From
The Member-Secretary
Chennai Metropolitan
Development Authority
1, Gandhi Irwin Road
Egmore, Chennai 600 008

Letter No. *Ac/27917/02*

sub: CMDA - Planning Permission - Construction
of Residential/Commercial Building at
Plot no 80, United India Nagar, 2nd Main Road,
in T.S. no. 103, Block no. 17 of Ayazavaram V.P.

ELEVATION

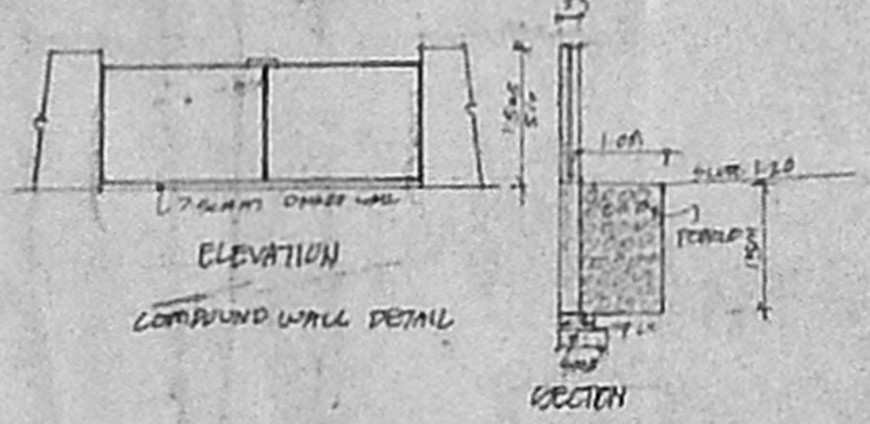
- ① Car parking lots to be shown as per D. & S. 2.50m x 5.00m
- ② Two nos of 4.00m wide gates with 7.5cm height dwarf wall along the gate L_s to be indicated.
- ③ Section and elevation of compound wall showing the gradient to slope 1:20 towards percolation pit.
- ④ Title of the floor plan completely orientated.
- ⑤ Sewer shaft for the 1st floor balcony should be at level level.
